Our Ref: 3972/20190718/LS/TB

Re: Agency Comments on the Concrush Response to Submissions (SSD 8753)

This letter provides a response to the comments provided by Lake Macquarie City Council (LMCC) and the NSW Environment Protection Agency (EPA) on the *Concrush Increase to Capacity Project - Response to Submissions Report* (Umwelt May 2019).

**SOIL & WATER MANAGEMENT PLAN**  
SCALE 1:500

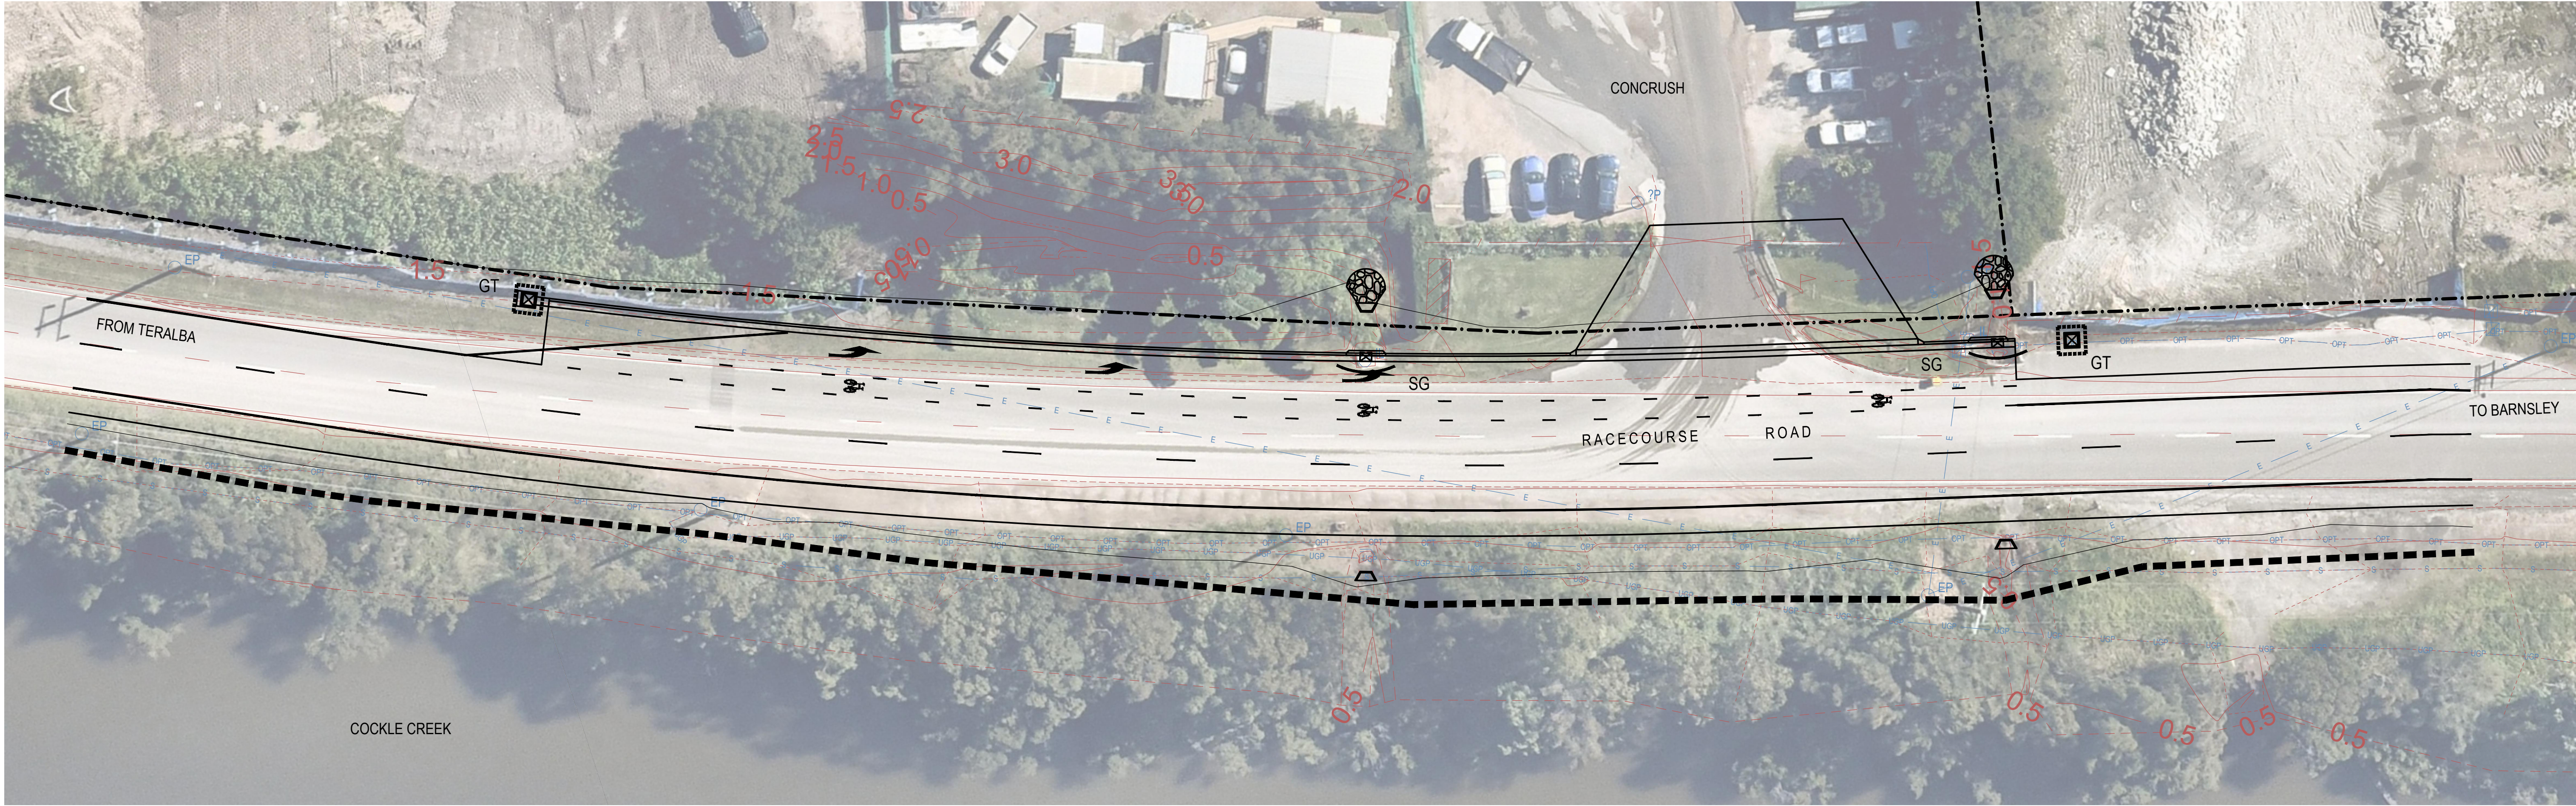
Key comments	Response
<p>Council retains the position that permanent drainage structure such as a concrete v-drain with drainage pits and associated piping or K&G with appropriate drainage should be constructed for the full frontage of the facility. Driveway access is to comply with Council Standard EGSD 202 -2 and be constructed of concrete.</p>	<p>As discussed with LMCC at the meeting on 4 July 2019, it is not considered practical to establish kerb and guttering or concrete v-drains along the proposed frontage to Racecourse Road as there are no other existing drainage structures to tie in with. It is not considered practical to design or construct drainage structures for an isolated section of Racecourse Road without consideration of the adjoining land. In the local area the closest kerb and guttered area is within the residential area of Teralba approximately 1.65 kilometres to the south.</p> <p>The Concrush access driveway will be designed to comply with LMCC Standard EGSD 202-2 and be constructed of concrete.</p>

#### DETAIL PLAN

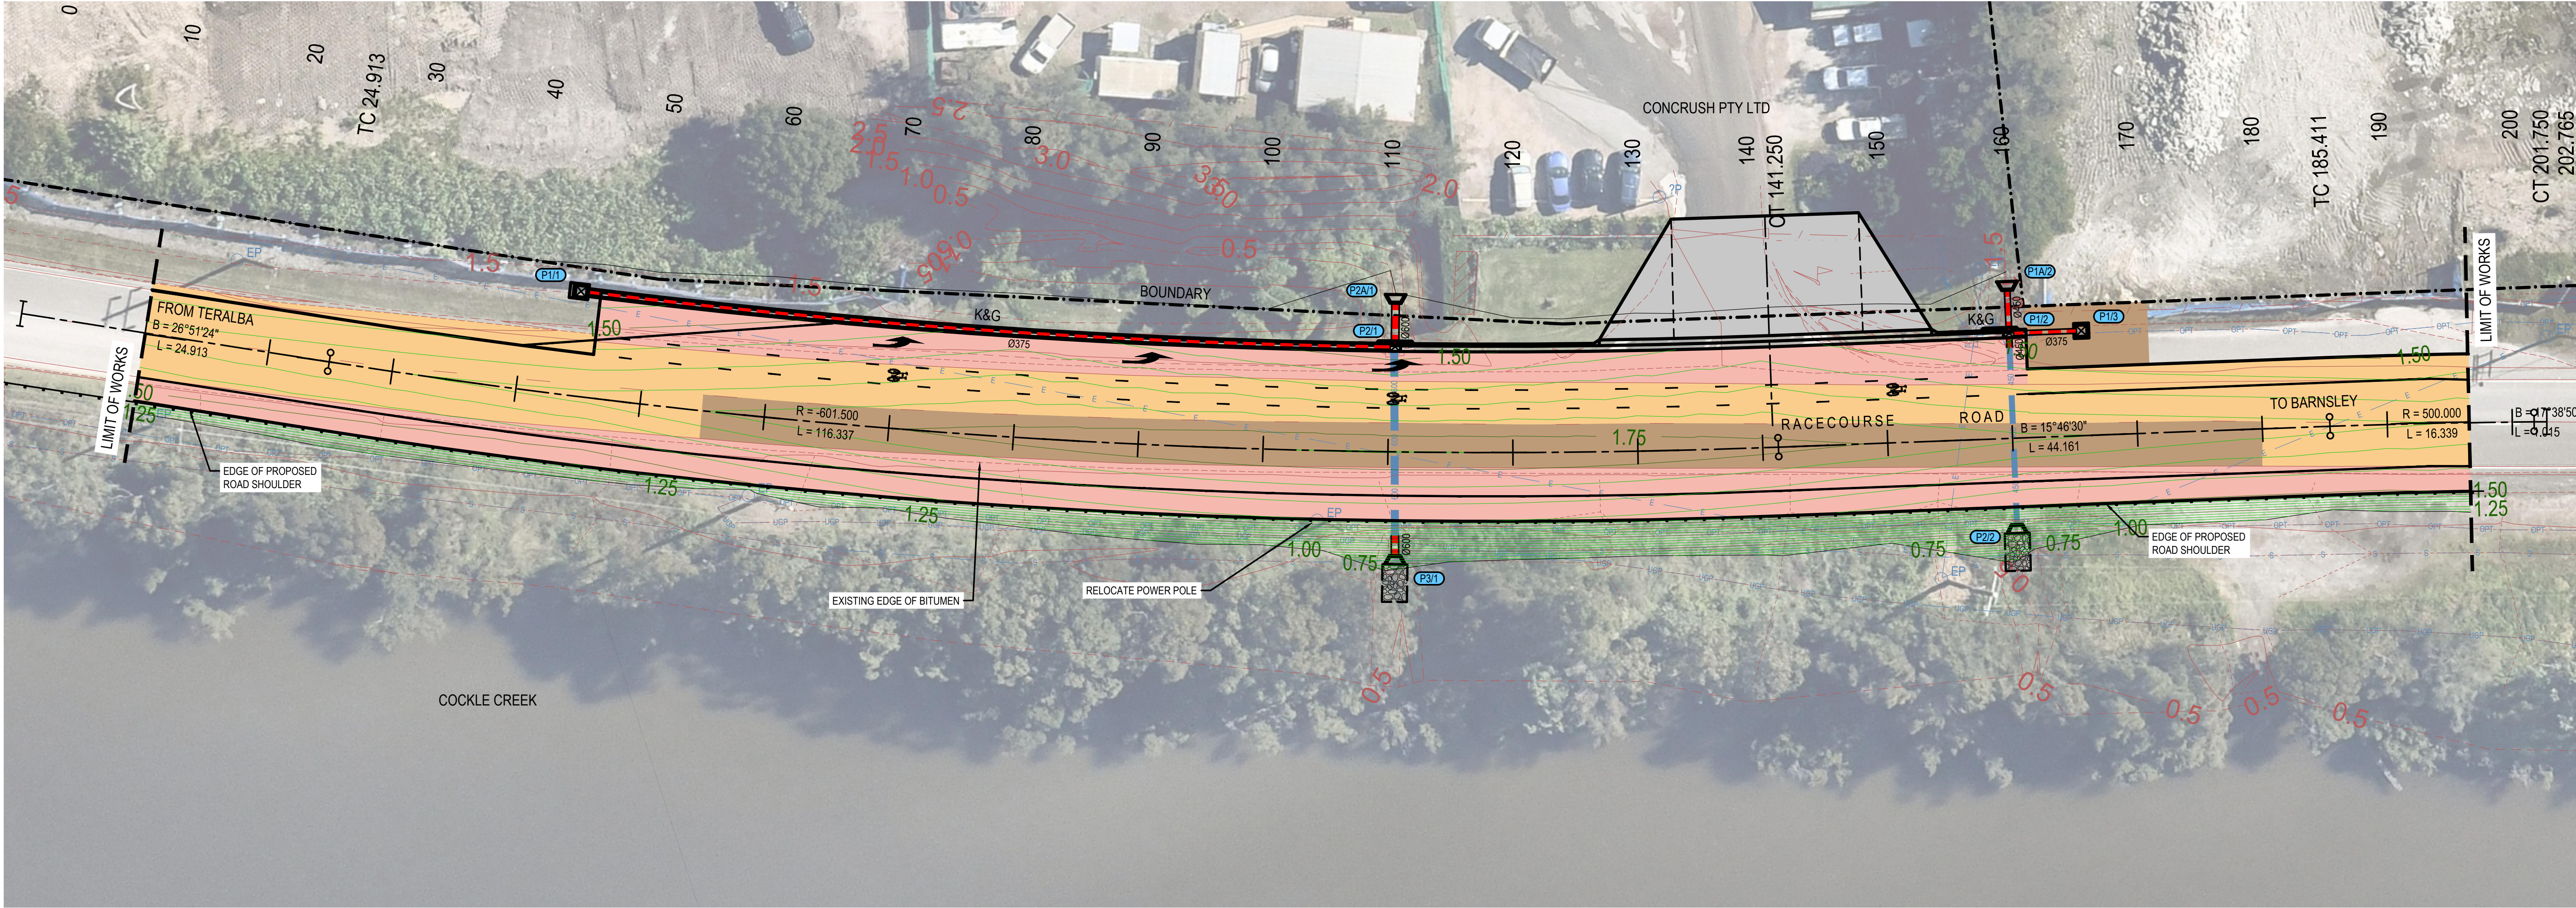
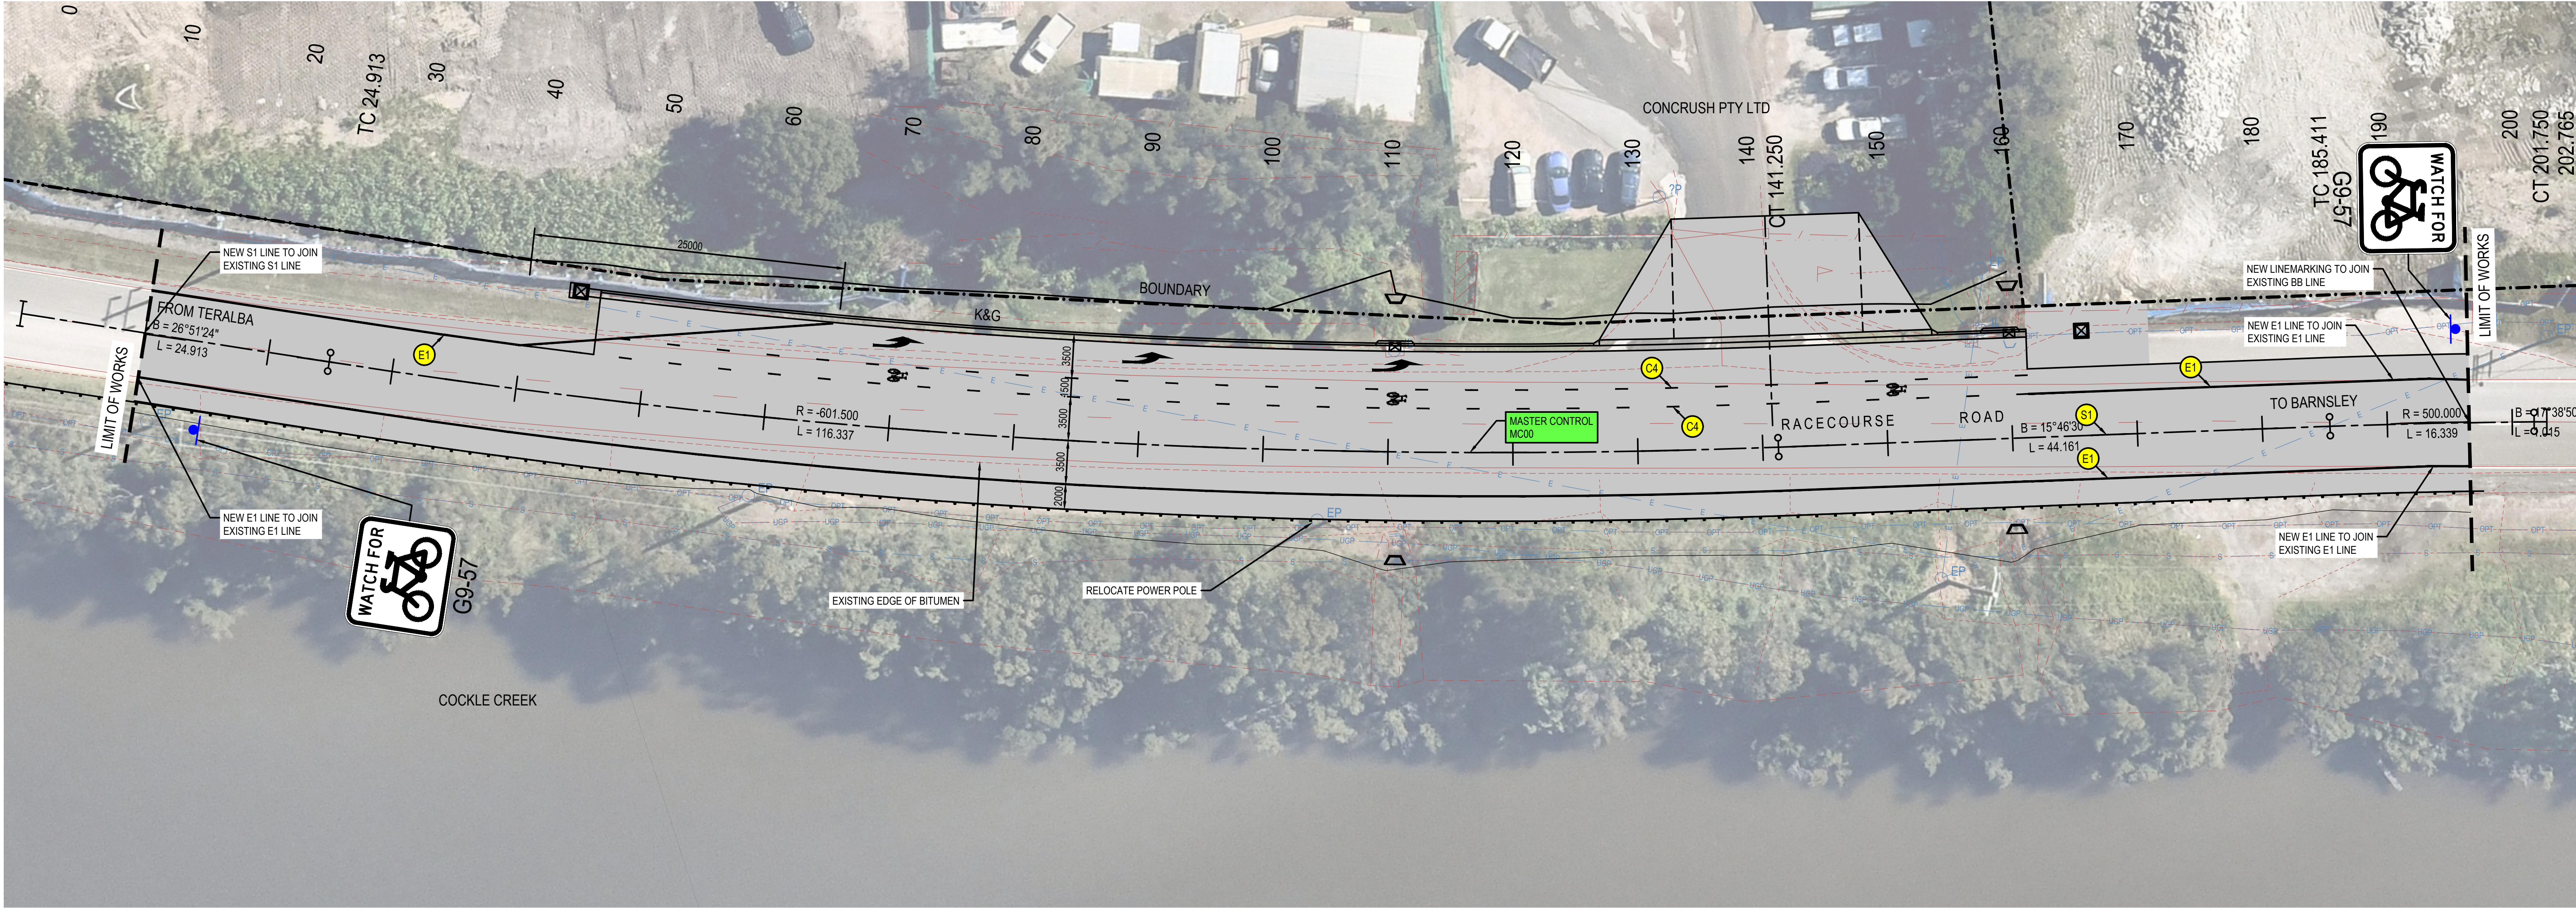
Key comments	Response
Road Design	
<p>Appendix E of the Response to Submissions document (April 2019), identifies only a BAL turning treatment is required. However the submission appears to use incorrect figures from Austroads Guide to Traffic Management Part 6: Intersections, Interchanges and Crossings (Austroads 2017). Figure 2.26 (b) graph shall be used to determine the required turning treatments, as the speed limit of the road is 80 kph, rather than Figure 2.26 (c).</p>	<p>Better Safety Futures identified that there is a typographical error in the <i>Guide to Traffic Management Part 6: Intersections, Interchanges and Crossings</i> (Austroads 2017) which resulted in the incorrect figure being referenced in Appendix E of the RTS. The correct figure reference is 2.26(b) for the existing speed limit of 80 km/h on Racecourse Road.</p> <p>At the meeting with LMCC on 4 July 2019 Concrush identified that a more appropriate speed limit for the section of Racecourse Road in the vicinity of the Concrush site would be 60 km/h. LMCC did not disagree with Concrush on this matter but identified that it was NSW Roads and Maritime Services (RMS) that determined speed limits and that the timeframes involved in a review of speed limits are often lengthy. If the speed limit for Racecourse Road was to be reduced to 60 km/h then the turning treatments identified in the RTS Report would be appropriate. Concrush has identified that in discussions with residents along Racecourse Road the issue of traffic speed is generally their greatest concern.</p>

<p>A CHR(s) and AUL(s) treatment are required at the entry to the development site. Racecourse Road also has a high volume of heavy vehicles (approximately 11%) increasing the risk of rear end crashes involving vehicles entering the site. Therefore turning treatments of CHR(s) and AUL(s) are required to be installed as part of the development. These entry treatments are required to be designed to cater for the largest vehicles expected to enter the site.</p>	<p>The turning treatments identified in the Ausroads 2017 guideline for a road with 80 km/h speed limit and the relevant turning and traffic volumes are a channelised right turn with a short turning lane (CHR(s)) and an auxiliary left turn with a short turning lane (AUL(s)) as per Figure 2.26(b).</p> <p>The majority of heavy vehicles accessing the Concrush site do so from the south. This is because the route through Teralba is a more direct route from the majority of the Newcastle/Lake Macquarie area, it is closer to a main road being Five Island Road and also because there is a 4.2 metre height restriction on the railway bridge on Racecourse Road to the north of the Concrush site. LMCC has informed Concrush that it plans to place a 5 tonne weight restrictions on the weir on The Weir Road to the north west of the Concrush site, the access road to Concrush from the north. This would effectively restrict heavy vehicles from accessing the Concrush site from the north. As such, heavy vehicle access will be from the south resulting in a left turn from Racecourse Road into the site and a right turn when exiting the site.</p> <p>During the meeting with LMCC it was agreed that an AUL(s) is an appropriate turning treatment for vehicles turning left into the Concrush site from the south. It was also discussed that a CHR(s) is not warranted as there would not be heavy vehicles turning right into the site following the 5 tonne weight restriction on the weir. It was agreed that a basic right turn (BAR) would be appropriate in this circumstance and that if in the future there was a change such that there was no weight restrictions on the road leading to Concrush from the north then the need for a different right turn treatment into the Concrush site could be investigated.</p> <p>Concrush will engage a civil engineering consultant to design a AUL(s) and BAR for the site entry/exit.</p>

<p>Cycle lane provision (northbound) and shoulder provision (southbound) is required to transition cyclists safely through the treatments.</p>	<p>Cycle lane provisions would be accommodated in the turning treatment design to be developed by a civil engineering consultant to be engaged by Concrush.</p>

<p>The CHR and AUL treatments and associated signage and linemarking are required to be endorsed by Council's Traffic Facilities and Road Safety Committee (TFC) and approved by Council prior to construction.</p>	<p>The turning treatments designs will be developed by a civil engineering consultant and submitted to LMCC's Traffic Facilities and Road Safety Committee for approval prior to construction.</p>
<p>Site Contamination</p>	
<p>Council concurs with RCA's response to the EPA comments, which confirmed Council's initial review and evaluation of the RCA report, that an EPA accredited Contaminated Site Auditor was not required. The EPA has withdrawn that requirement and is now in acceptance to the report being prepared or certified by an accredited Contaminated Site Consultant.</p>	<p>The RCA report has been certified by an accredited Contaminated Site Consultant.</p>
<p>The PFAS testing suggested by the EPA has also been debated by RCA as unnecessary due to the historic use of the site and lack of evidence to suggest that PFAS was ever used. The EPA has also accepted RCA's response, and PFAS testing is no longer required.</p>	<p>PFAS testing is not required and will not be undertaken.</p>
